CITY OF ALBUQUERQUE

**Re: Cliff's Amusement Park-Water Play Structure,
Request for Temporary C.O. - Disapproved
Engineer's Stamp dated: 01-05-12, (F17/D031A)
Certification dated: 06-08-12**

DRAWN BY: BJB  
REVIEWED BY: GLD  
DATE: 12/23/2011  
PROJECT NO.: 11-0019  
DRAWING NAME: GRADING AND DRAINAGE PLAN

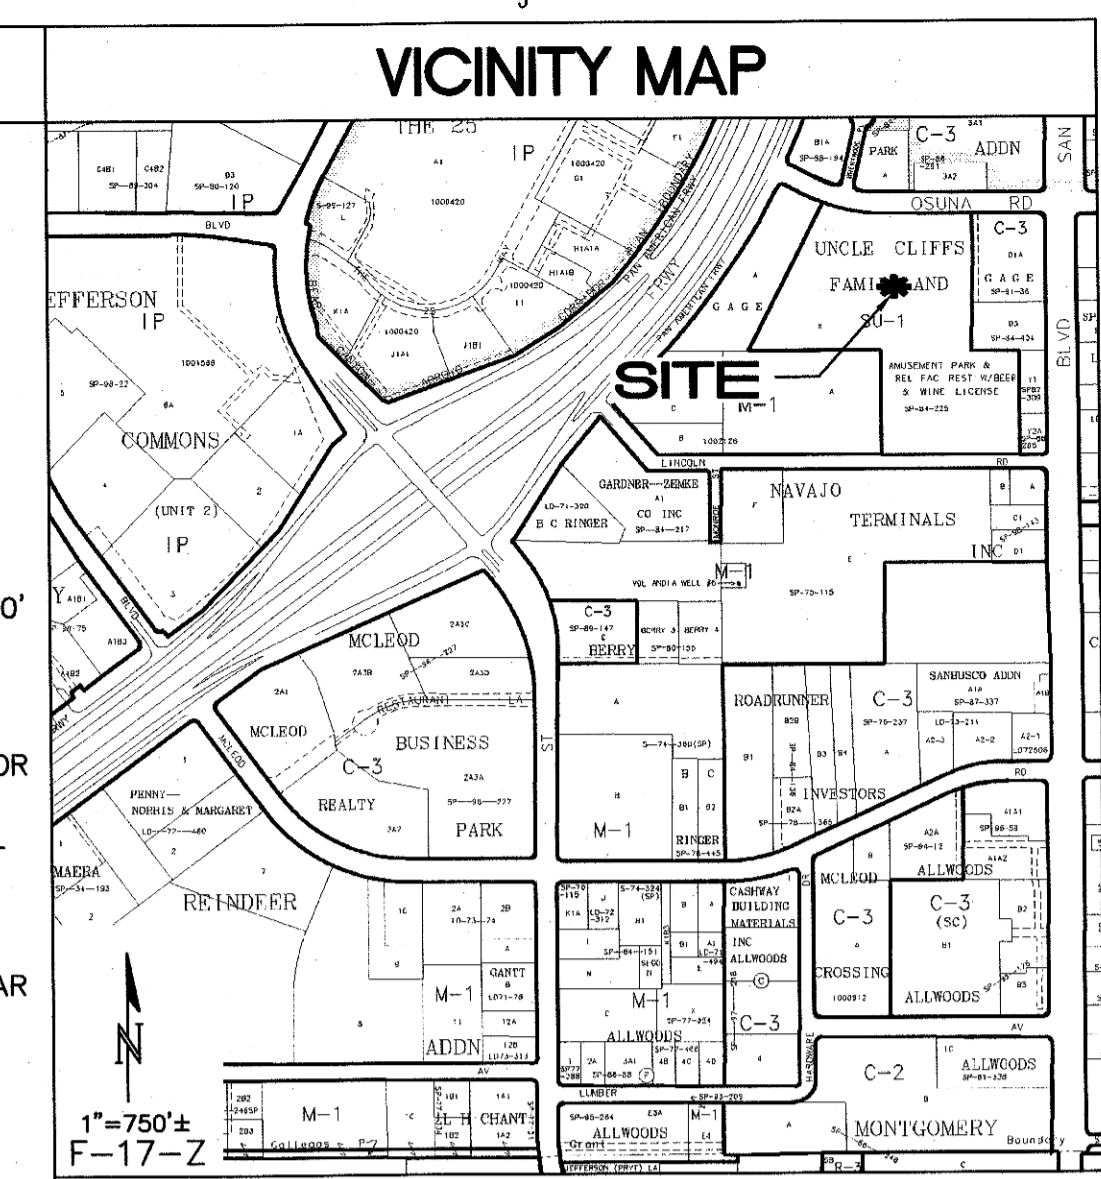
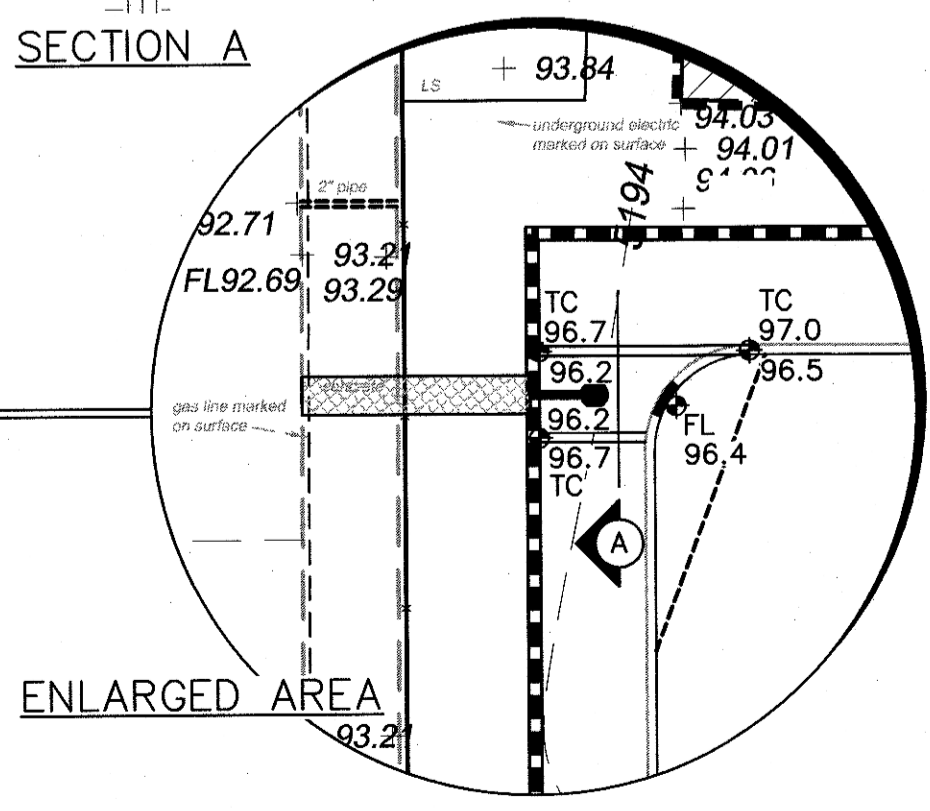
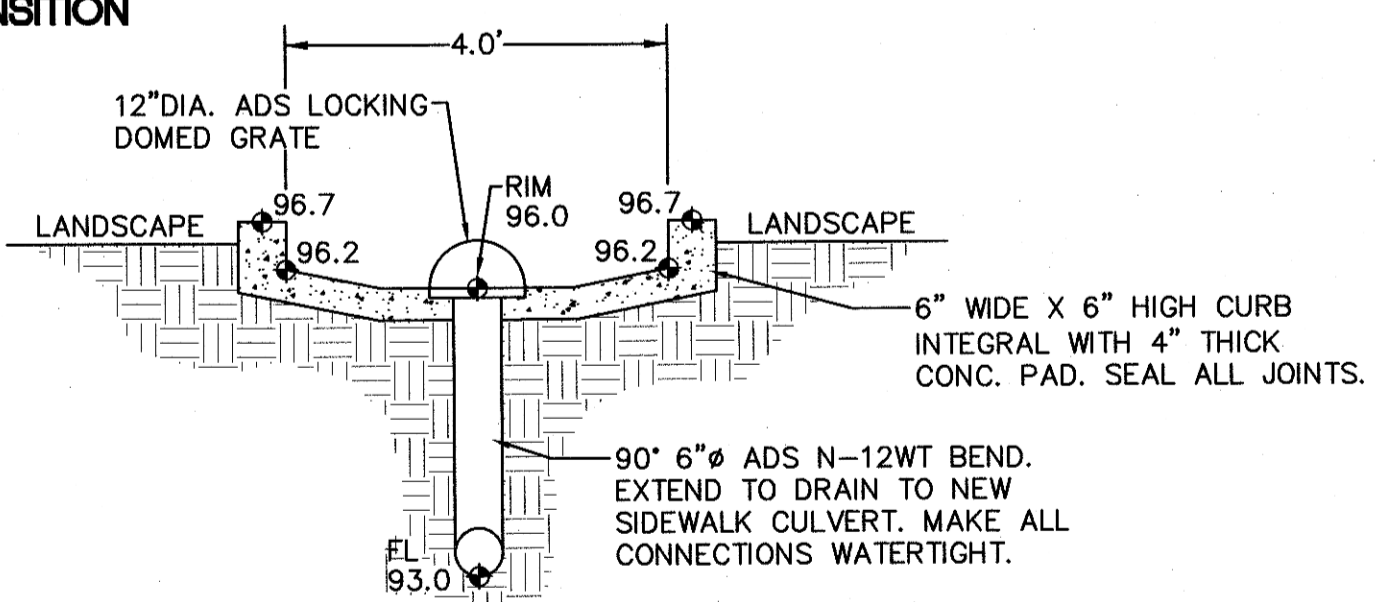
1. As built elevations are not evident with this certification. Please provide as built elevations.
2. This site was not intended to be phased; phase one is upstream of the discharge locations, how does this effect the lower site? Please demonstrate the lower location meets the design intent. Are the sidewalk culverts in place?
3. If this site adheres to the original design intent please provide adequate elevations which reflect the on-site conditions. Finished floor and relevant elevations should be provided with all Certificate of Occupancy requests.
4. The Engineer's certifying language will need to per the DPM; within this language, any deviation of plan will need to be clarified. Any remaining site issues will need to be addressed with in this language.
